A/12/21/L

Waterton House Arundel Road Angmering BN16 4JR

Listed building consent for minor exterior & interior alterations including 3 x new windows, back elevation, demolition of an interior dividing wall & other minor works.

Martyn White
Principal Conservation Officer,
Planning Services

Figure 1 Ground Floor Plan Ref 1

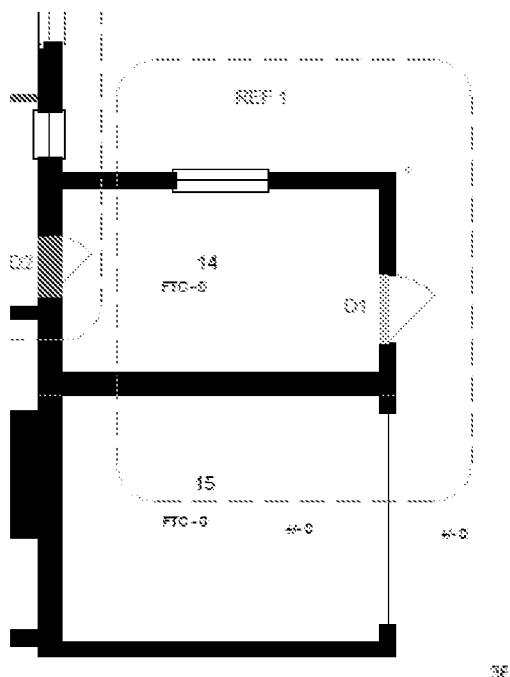
The intention is to create a utility room in the room identified as 'room 14'. This involves creating an opening between the kitchen (room 13) and this space, introducing a new door, as well as sealing shut the existing stable door on the northern elevation. I note that the intention is to use materials and design details appropriate for a listed building and consider that this element of the proposal is acceptable.

Figure 2 Ground Floor Plan Ref 2

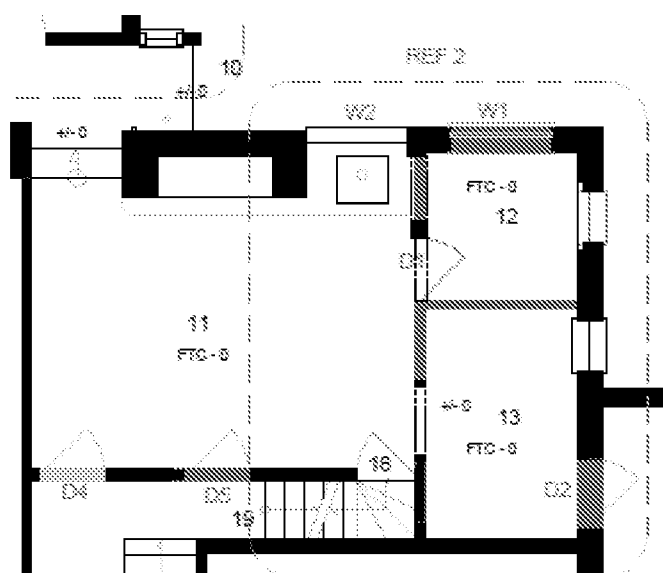
The alterations to the kitchen include the partial removal of internal walling, relocation of a door, replacement of a modern window and the introduction of another one. Whilst this element will result in the removal of some historic fabric, it is considered that the amount removed will not cause harm. Both the replacement window and the additional window are of an appropriate design for this building.

Figure 3 Ground Floor Plan Ref 3

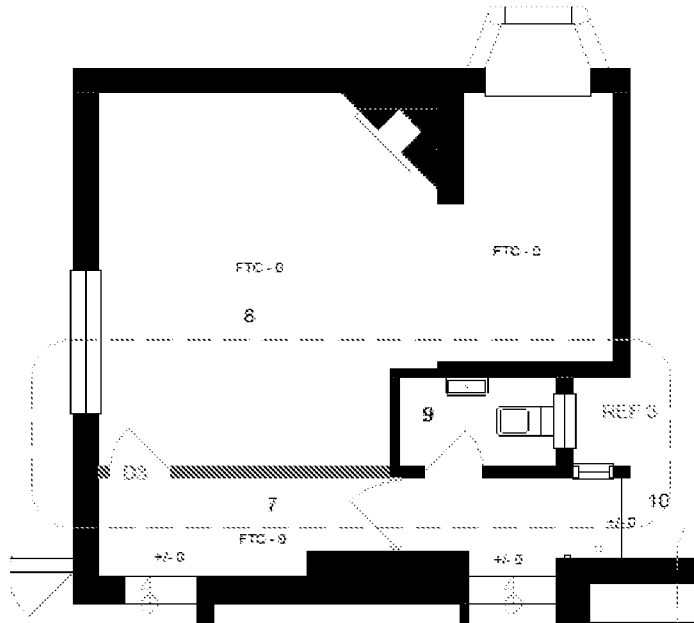
Both the alterations to the ground floor sitting room and the first floor bathroom are such that they will not harm the layout or significance of the building. Both elements are therefore considered to be acceptable. Likewise, the replacement window is more appropriate for the listed building.
